From: Laura Gibbons <Laura.Gibbons@arun.gov.uk>
Sent: 21 September 2021 08:16
To: Planning.Responses <Planning.Responses@arun.gov.uk>
Subject: RE: Planning Consultation on: A/168/21/PL

Engineers Comments Regarding Surface Water Drainage

Application No: A/168/21/PL

Description of Works: Erection of 76 No. dwellings, means of access, public open space, play areas, associated infrastructure & landscaping. This application is a Departure from the Development plan, is in CIL Zone 5 and is CIL Liable as new dwellings & affects a Public Right of Way.

Infiltration Test Results and Calculation of Infiltration Rates

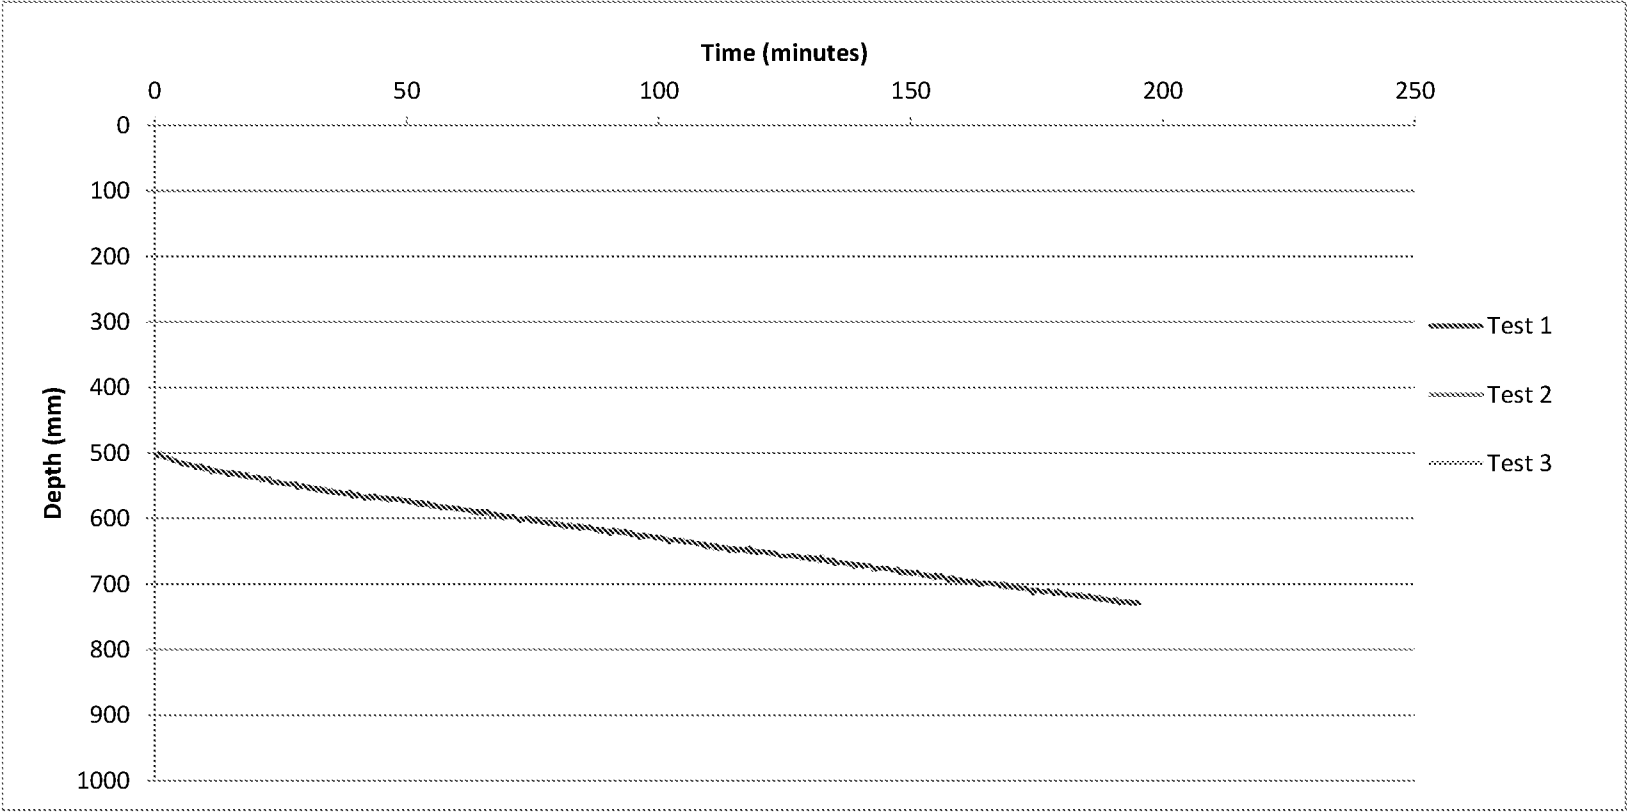
A surface water drainage strategy has been submitted with this application. The strategy identifies an attenuation drainage strategy with discharge limited to 2.9l/s. We note that winter groundwater monitoring has been completed and ground water was found at just over 1m depth throughout the site. Winter infiltration testing was completed, but three repeat tests were not completed at any location. The single test completed at each location indicate that infiltration is viable here. Full winter infiltration testing in accordance with BREDG365 must be completed.

“Infiltration rates for soakage structures are to be based on percolation tests undertaken in the winter period and at the location and depth of the proposed structures. The percolation tests must be carried out in accordance with BRE365, CIRIA R156 or a similar approved method and cater for the 1 in 10 year storm event plus 40% on stored volumes (allowance for climate change) between the invert of the entry pipe to the soakaway, and the base of the structure. It must also have provision to ensure that there is capacity in the system to contain below ground level the 1 in 100 year storm event plus 40% on stored volumes. Adequate freeboard must be provided between the base of the soakaway structure and the highest recorded annual groundwater level identified in that location. Any SuDS or soakaway design must include adequate groundwater monitoring data to determine the highest winter groundwater table in support of the design. The applicant is advised to discuss the extent of groundwater monitoring with the Council's Engineers.
